**Harvests
Norton Lane
Norton
Chichester
West Sussex
PO20 3NH**

29th June 2026

Objection to Planning Application – AL/20/26/PL – DRAINAGE

I also refer to the document 'FRA/Drainage Statement/Foul Drainage Impact Assessment Rev P05' posted on 15.06.26. Title – 'Flood Risk Assessment/Drainage Statement/Foul Drainage Impact Assessment'

Chart 1 – Groundwater Records

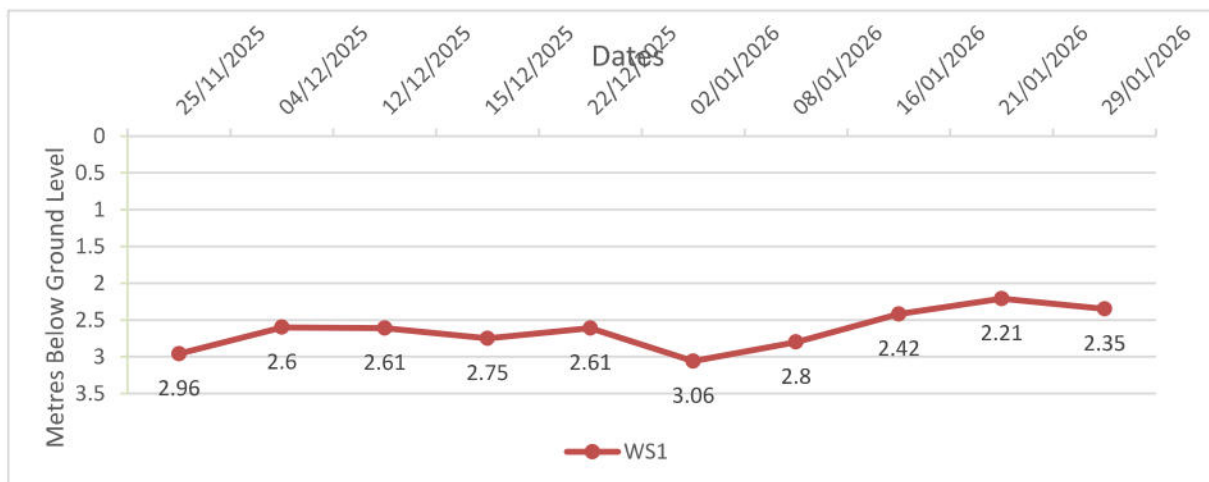
This has clearly not been done as the monitoring finished in late January 2026 whereas the peak is likely to be in March.

- 1.3. A ground investigation has been provided which includes winter groundwater monitoring up to the end of January 2026 and it is stated in the ground investigation report that groundwater levels are increasing up to a likely seasonal maximum in March. The current scope of the groundwater monitoring was previously agreed with ADC as part of pre-application enquiry.

This reinforces the key issue that testing has not been conducted at the appropriate time i.e. when groundwater levels are at their highest. It is somewhat unfortunate that the Applicant received apparently inappropriate advice from ADC in a pre-application enquiry. To rectify and overcome this inappropriate advice / agreement a period on winter groundwater monitoring should be undertaken to include the period when groundwater levels are at their highest (March).
